SPR EA1N and EA2 PROJECTS

DEADLINE 8 – COMMENTS ON VIEWPOINT 5 PUBLIC RIGHTS OF WAY (REP7-062)

Project: 1080 East Anglia One North and East Anglia Two
Date: 24th March 2021
Purpose: Notes responding to SPR's Deadline 7 submissions
Reference: 1080 BN08 Responses to Deadline 7 submissions.docx

EA1N Figure 29.37 - Viewpoint 5 Public Rights of Way, near Moor Farm (with National Grid GIS Substation) **REP7-062**

**Viewpoint 5 Public Rights of Way, near  
Moor Farm (with National Grid GIS  
Substation)**

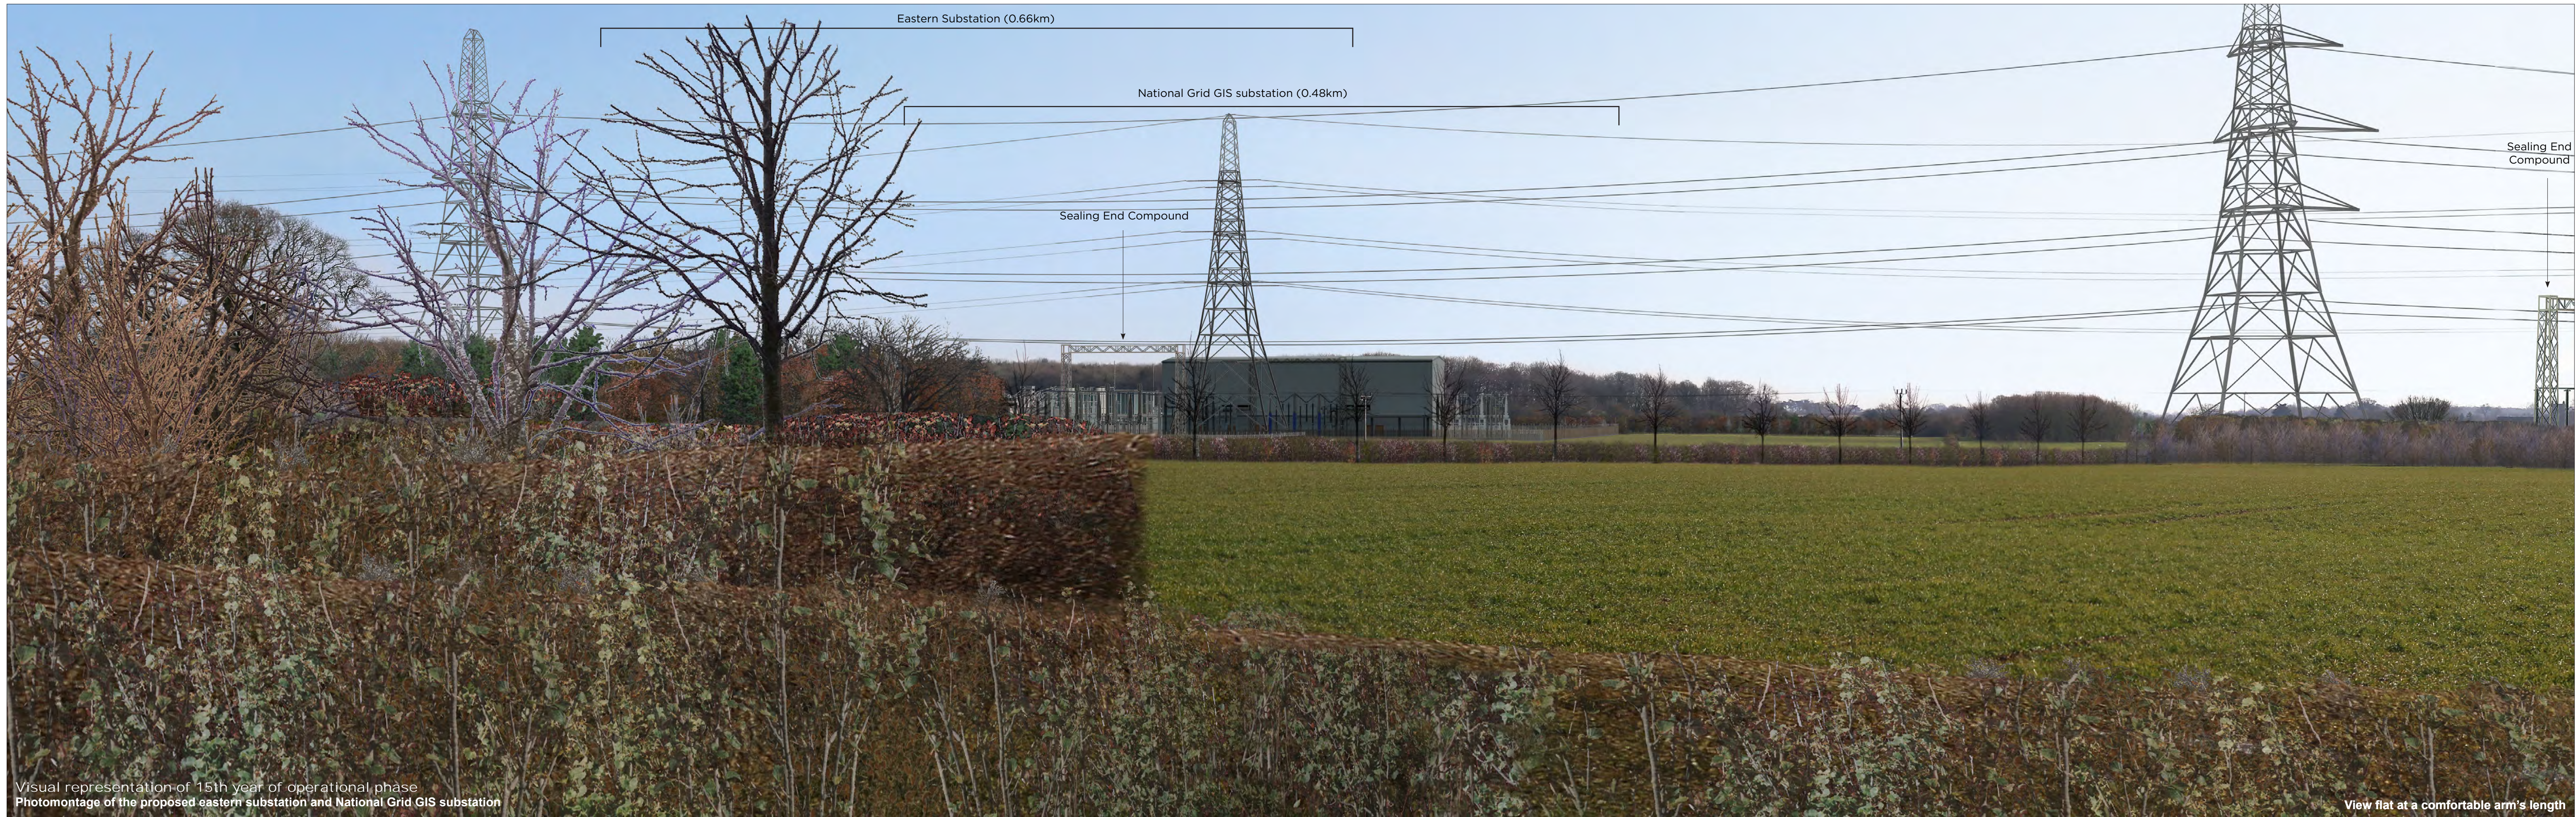
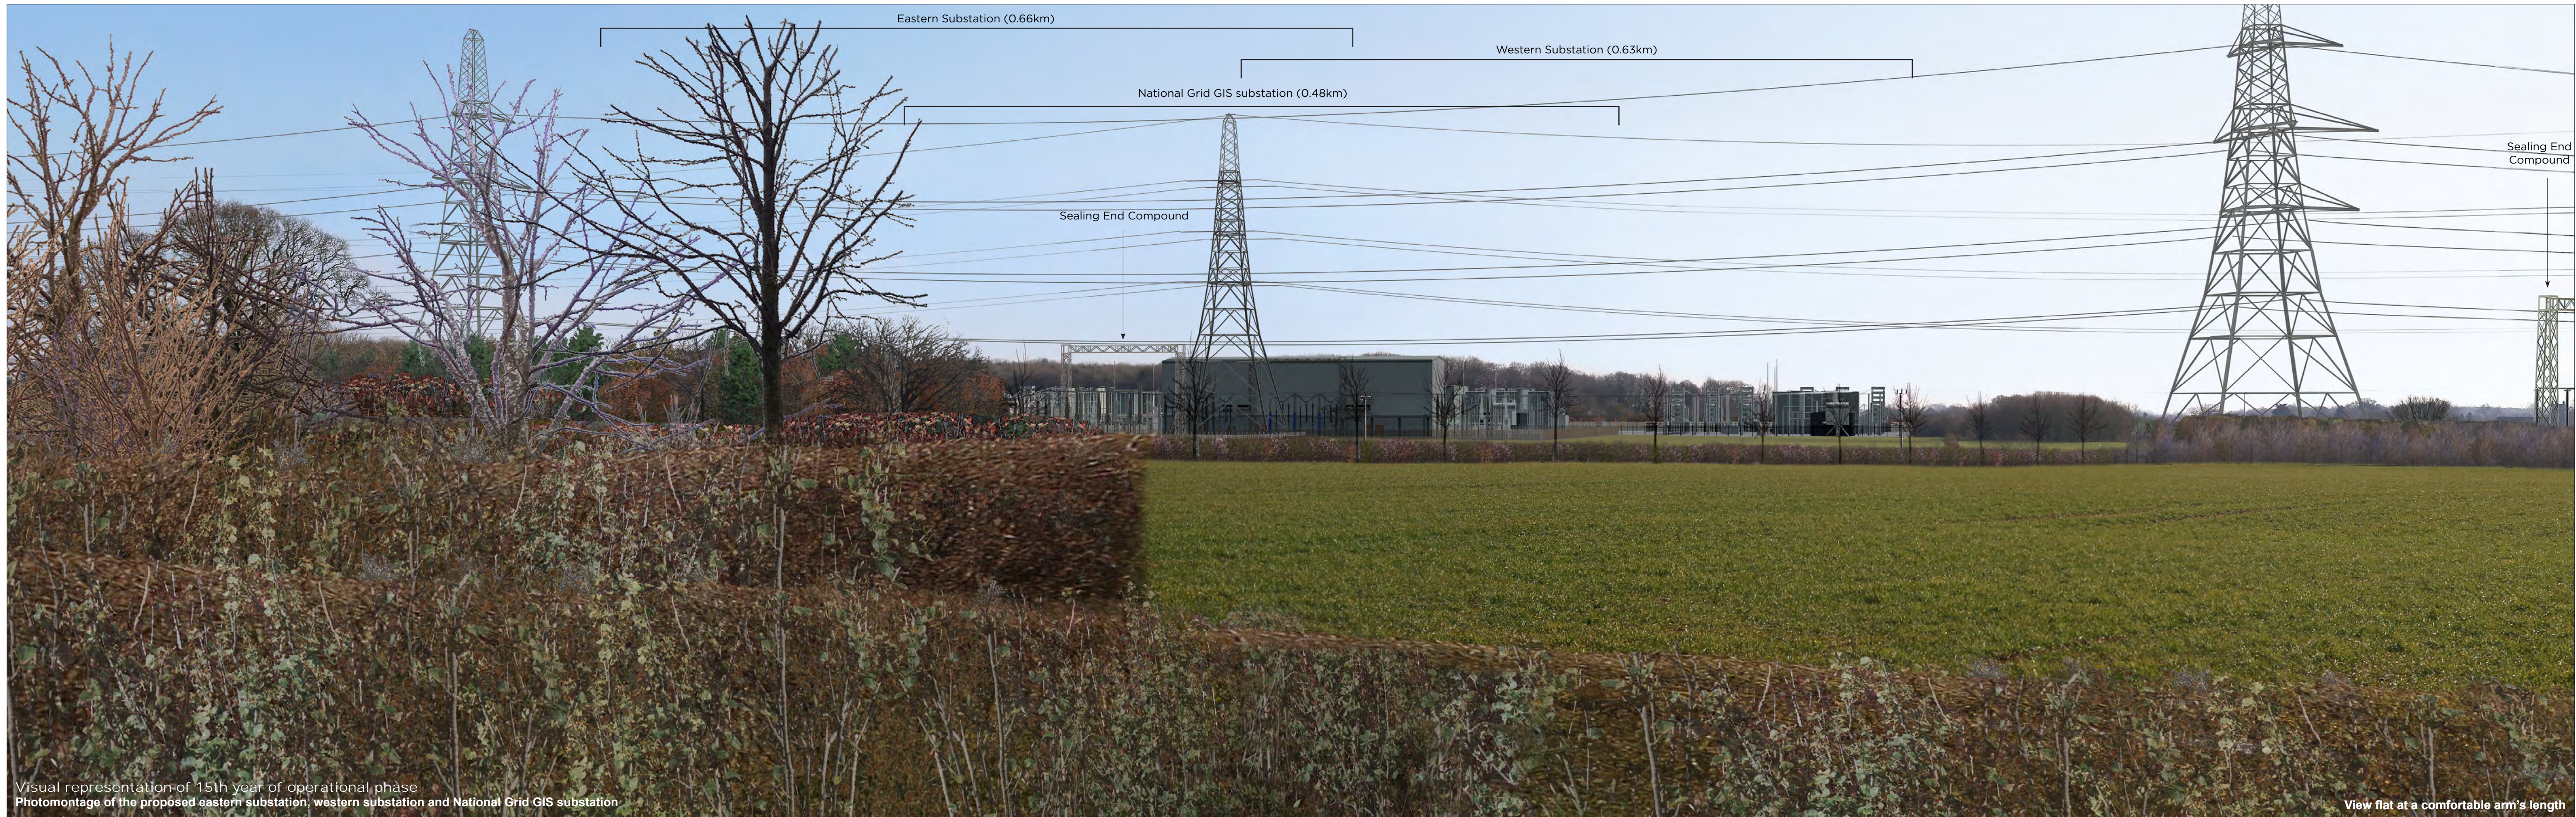
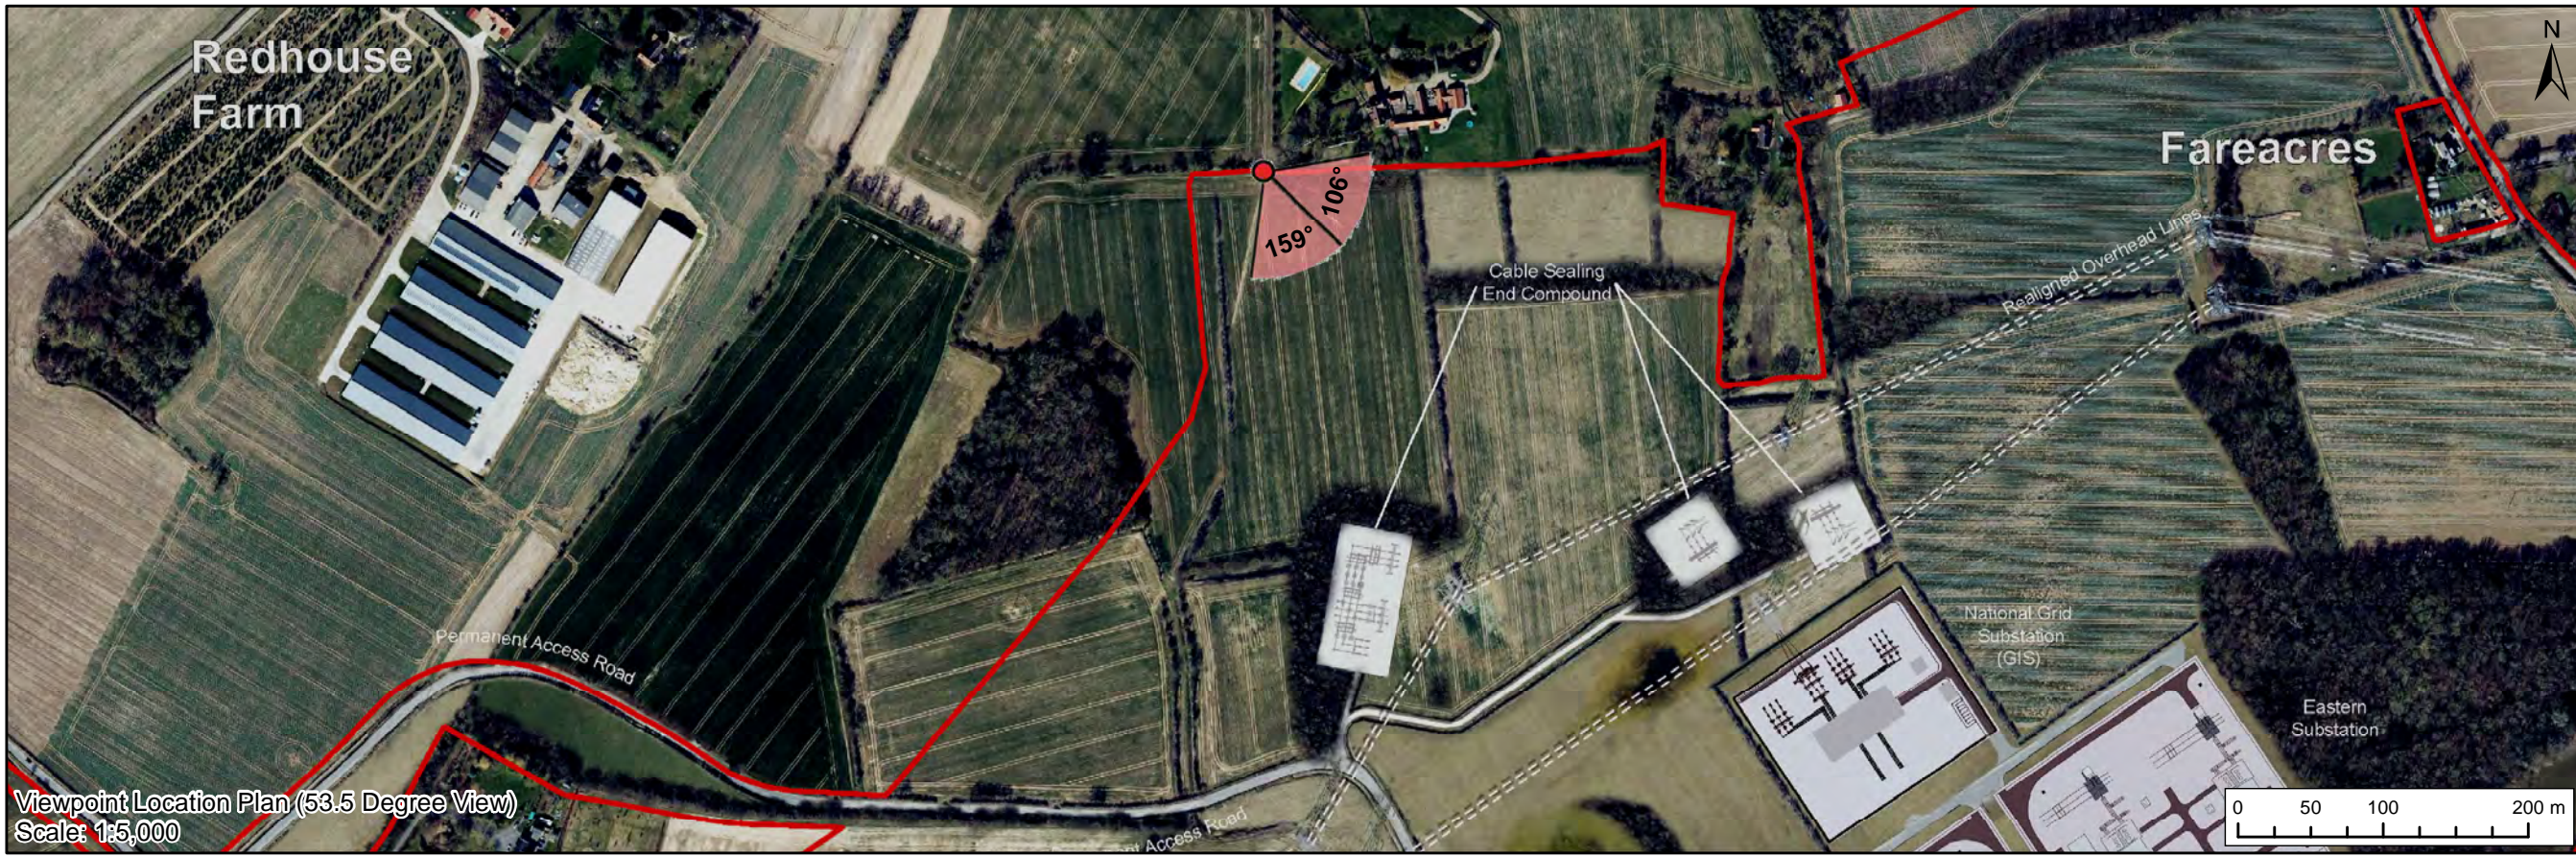
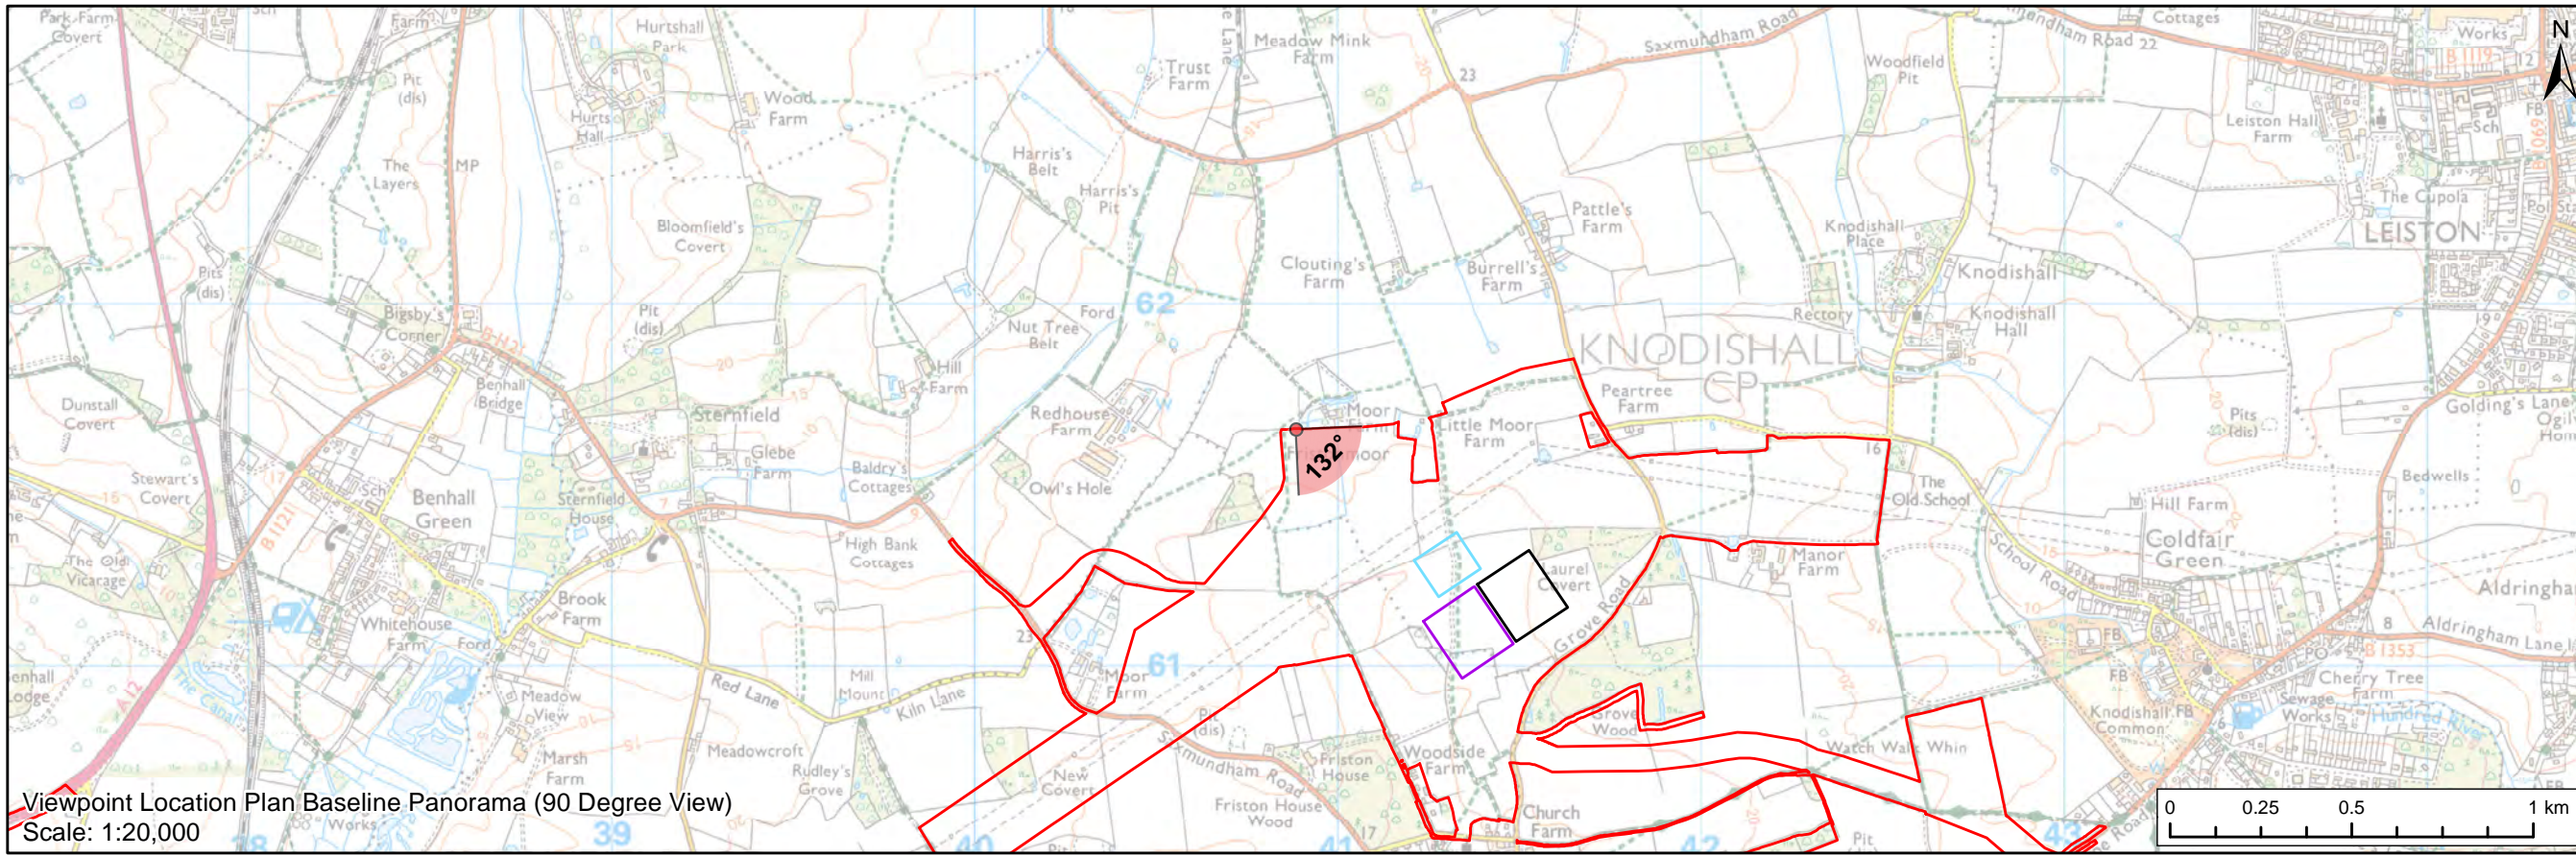
1. Visualisations from LVIA Vp 5 have now been prepared to show the GIS National Grid (NG) substation. (EA1N Figure 29.37 - Viewpoint 5 Public Rights of Way, near Moor Farm (with National Grid GIS Substation) **REP7-062**) These can now be compared with the visualisations previously submitted from LVIA Vp 5 (EA1N Landscape and Visual Impact Assessment Addendum - Appendix 5 - Viewpoint 5 **REP4-036**) which show the AIS NG substation. The following paragraphs set out the key issues raised by a comparison of the two sets of visualisations.

2. The AIS NG substation extends further to the west and contains a complex array of equipment, close to Vp 5 and also clearly visible from Fp 17 which runs south from Vp 5. This complex array of equipment is absent from the GIS NG substation.

3. Currently there are no proposals to plant within the area released by the smaller GIS NG substation. Although this area, to the north of the western substation, is outside the area restricted by the pylons, the extent of possible planting is already reduced by the location of the northern infiltration basin in this area.

4. As there is no additional planting proposed alongside the GIS NG substation, the reduction in the footprint allows views towards the western SPR substation beyond. Consequently, there is no significant reduction in the

overall extent of the view that it occupied by substation equipment. The land released by the use of a GIS NG substation could accommodate further planting and it could also allow for a redesign of the infiltration basin that is informed by potential landscape and visual effects. Despite the lack of additional planting there is a small reduction in visual intrusiveness as some of the visible equipment is further away from the viewpoint.

5. **REP7-062** includes 4 additional images (compared to **REP4-036**) that have the NG substation at the centre of the field of view. They are helpful as in the earlier visualisations the NG substation site is located at the 'join' between the two images; two images are necessary in order to encompass the horizontal spread of the whole substation complex when viewed from this location. The buildings within the AIS station, in particular are split by the join and so it is not easy to determine whether there is increased visual intrusiveness as a result of the larger GIS building.

6. In order to properly understand the differences between the visual impacts of the AIS and GIS NG substations from Vp 5 it would be helpful for the ExA to have a comparative set of images for the AIS NG substation; similar to the final four images in **REP7-062**. These visualisations should be presented in a single document in which the GIS visualisations alternate with the equivalent AIS images. This would not require any additional modelling.

7. The GIS NG substation is visually less complex than the AIS substation and would remove an area of complex equipment that is proposed to be located close to Vp 5 and Fp 17. This would result in a small reduction in visual intrusiveness, although it would also reveal views of the western substation to the south. There would be a greater reduction in visual intrusiveness if the land released by a GIS substation was planted and the infiltration basins realigned.
